From: [Kim Shilley](#)
To: [Zach Torrance-Smith](#)
Subject: RE: BL-26-00002 Fowler Creek Trails - Follow Up
Date: Wednesday, June 17, 2026 4:18:05 PM
Attachments: [image001.png](#)
[image002.png](#)
[image003.png](#)
[image004.png](#)

Subject: BL-26-00002 Fowler Creek Trails - Follow Up

I received an updated survey from the Fowler Creek Trails BLA applicants. Public Health had provided comments pertaining to well setbacks, as well as septic system permits and associated setbacks.

RECORD OF SURVEY A PORTION OF THE NE 1/4 OF SECTION 3, TOWNSHIP 19 NORTH, RANGE 14 EAST, W.M., KITITAS COUNTY, WASHINGTON

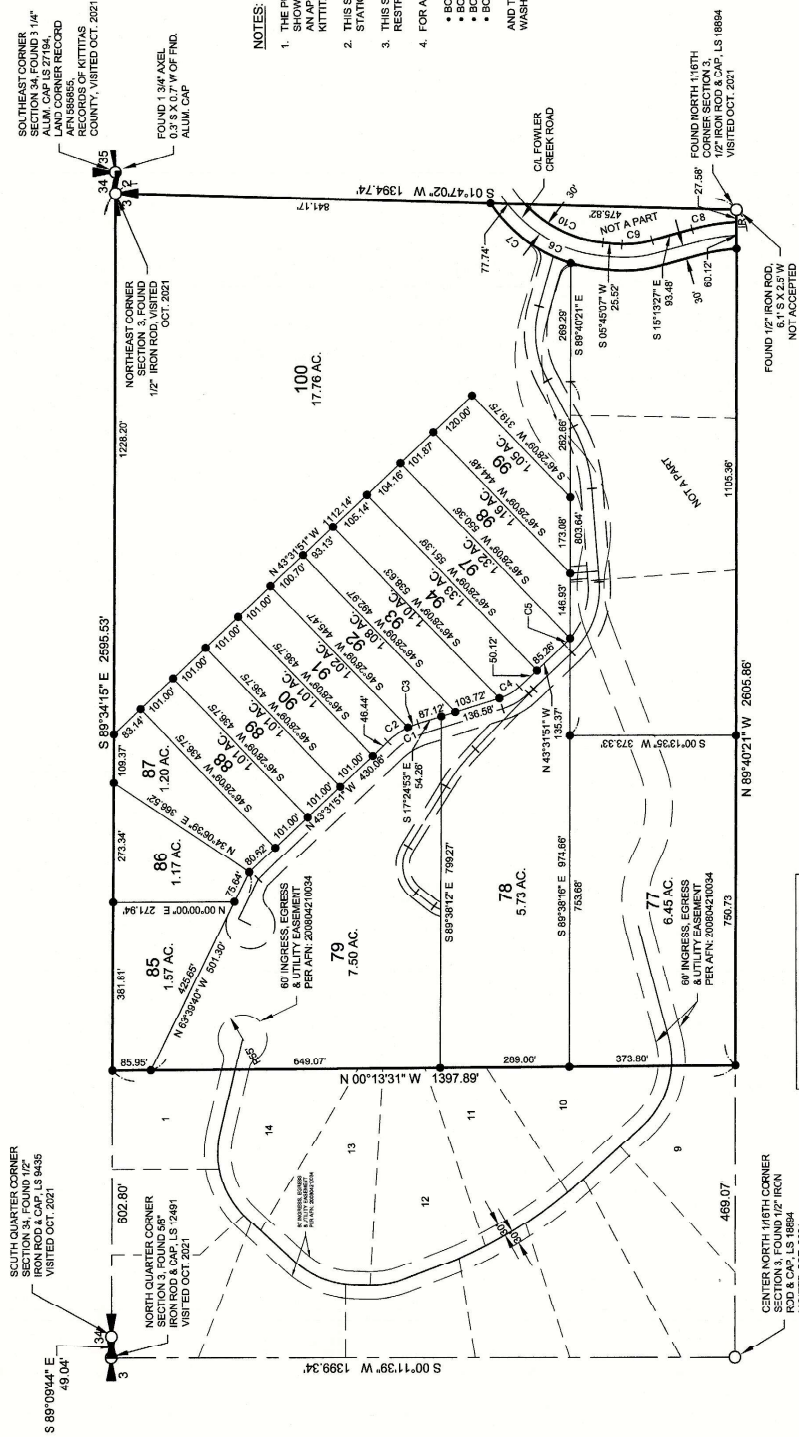
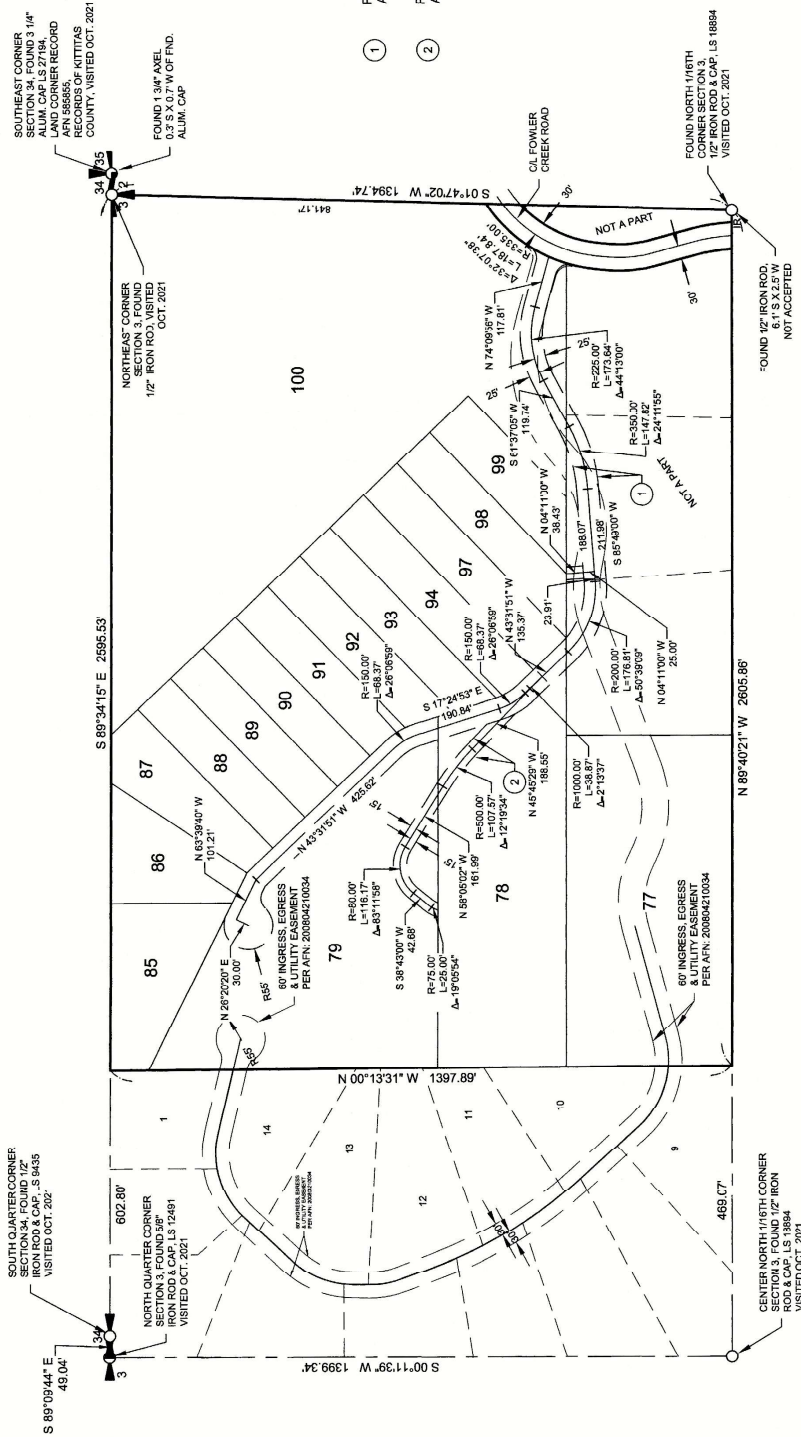
It appears that the wells have been removed from the new survey so I am unable to see if the 50' set back from property lines have been met.
